Application for a Non-Material Amendment Following a Grant of Planning Permission

Alterations to front elevation; removal of front doorway and new replacement matching window

23/00358/HOU

SOUTH ELEVATION

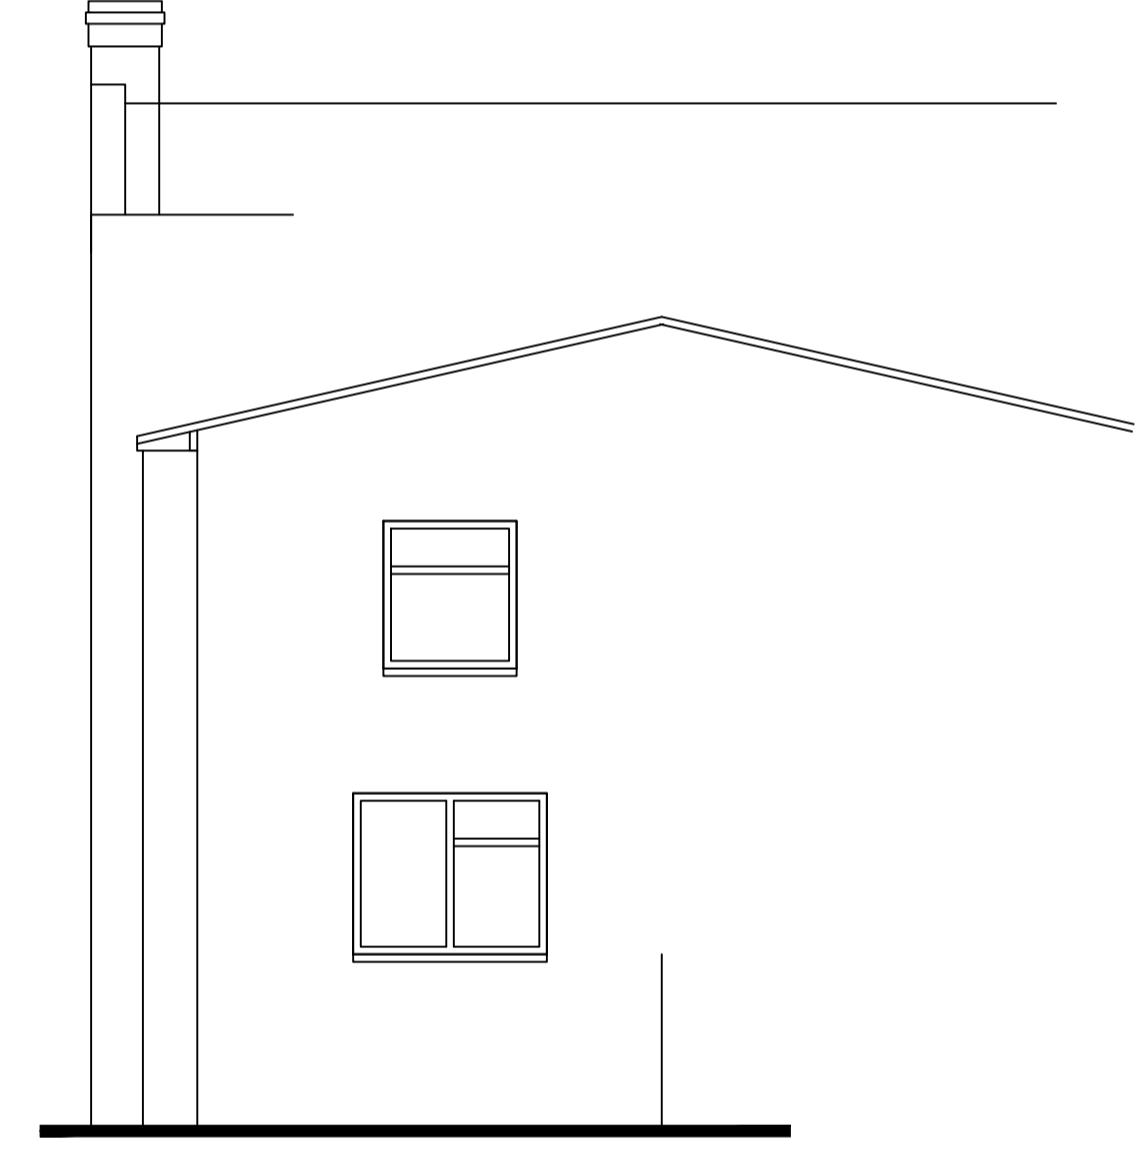
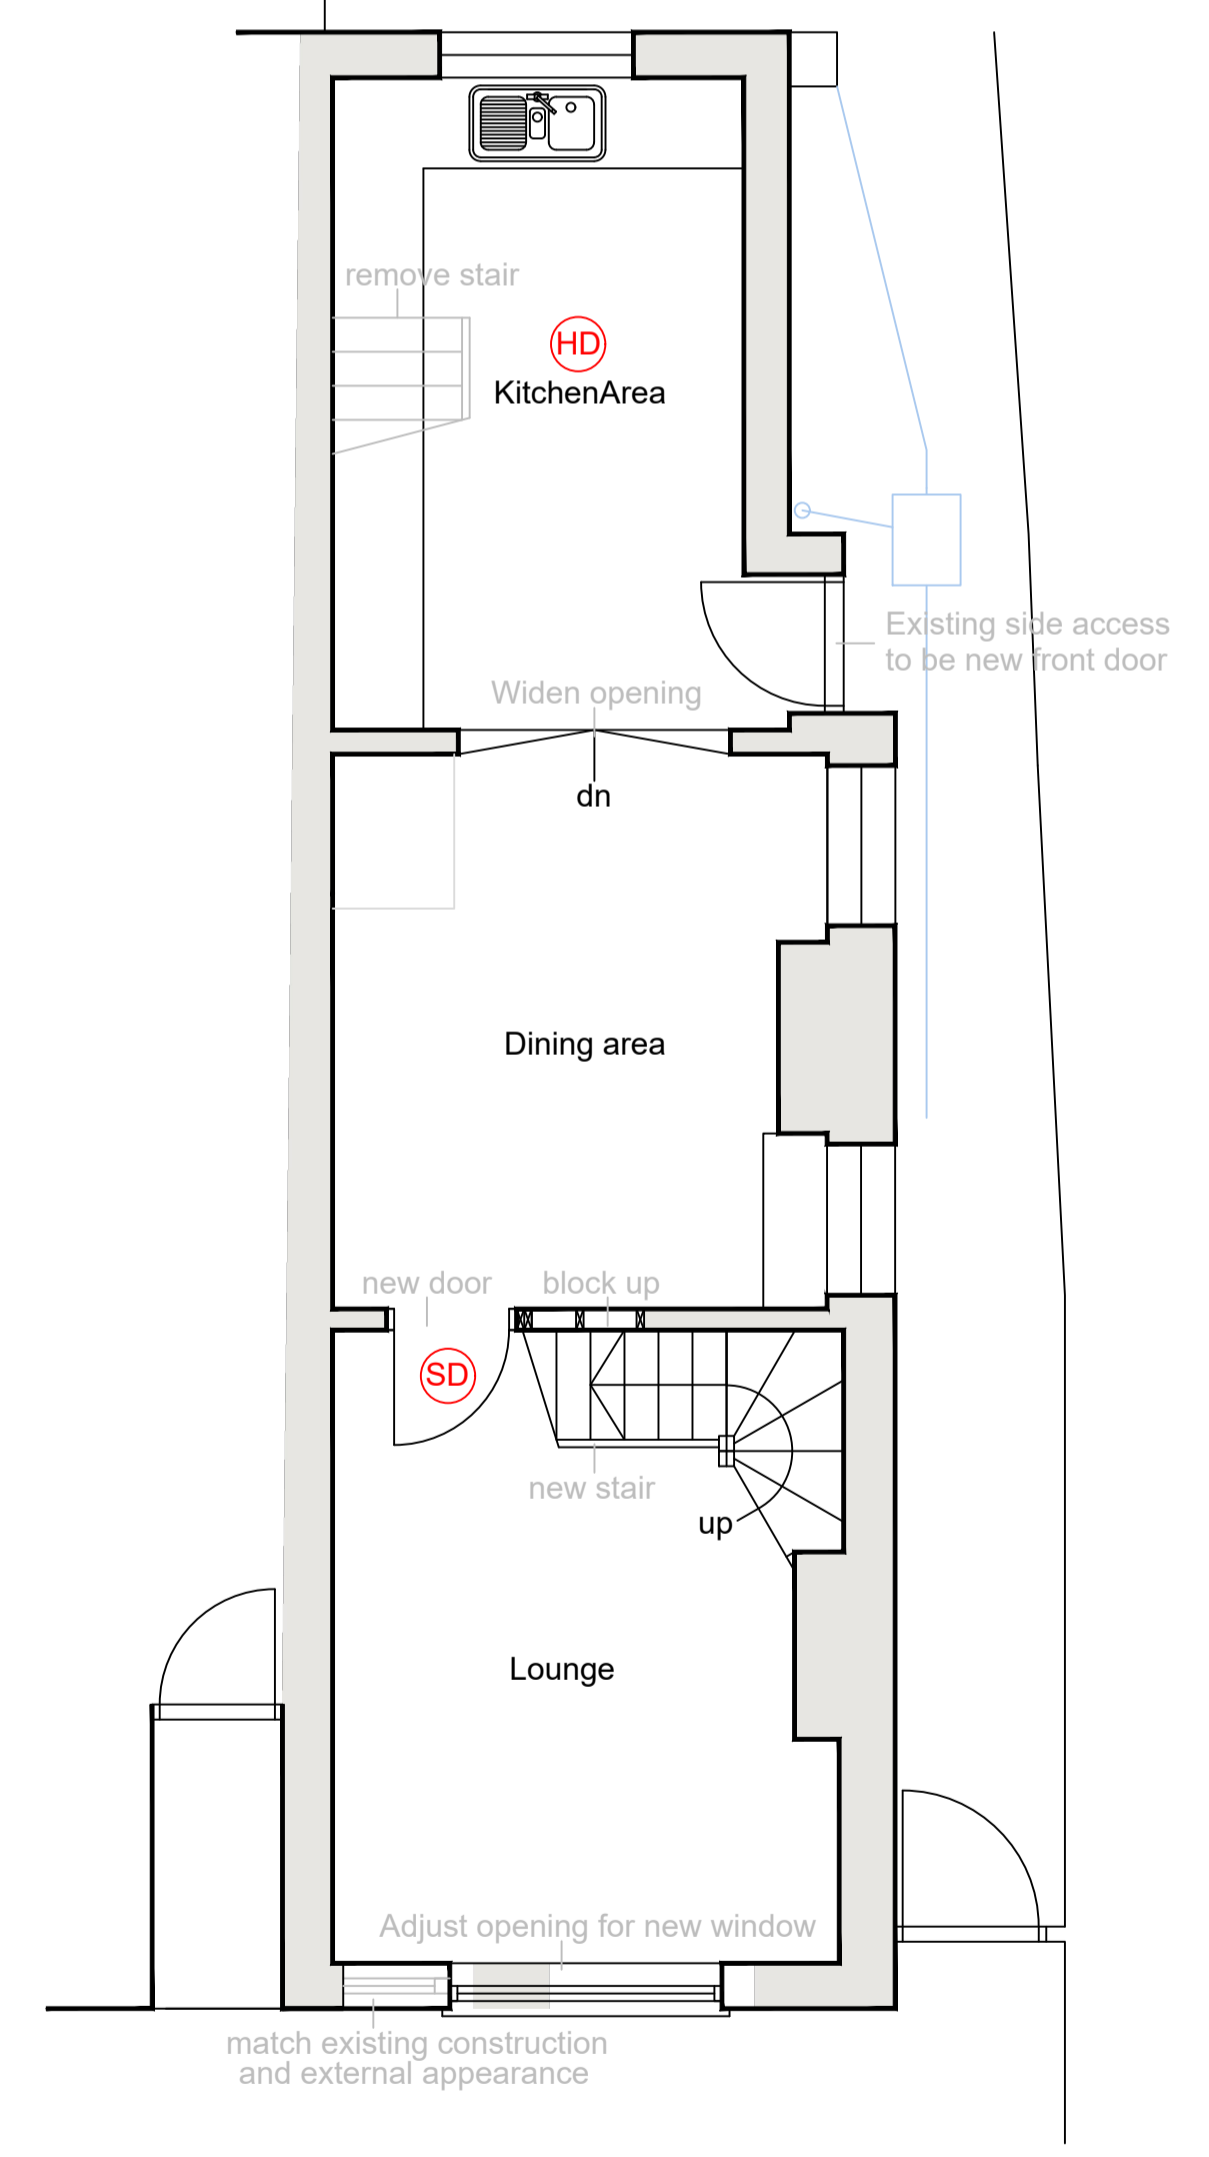
We propose a revision to the two windows on the front elevation, window width is to be reduced slightly.

Clients preference for a revised smaller window design to improve building appearance.
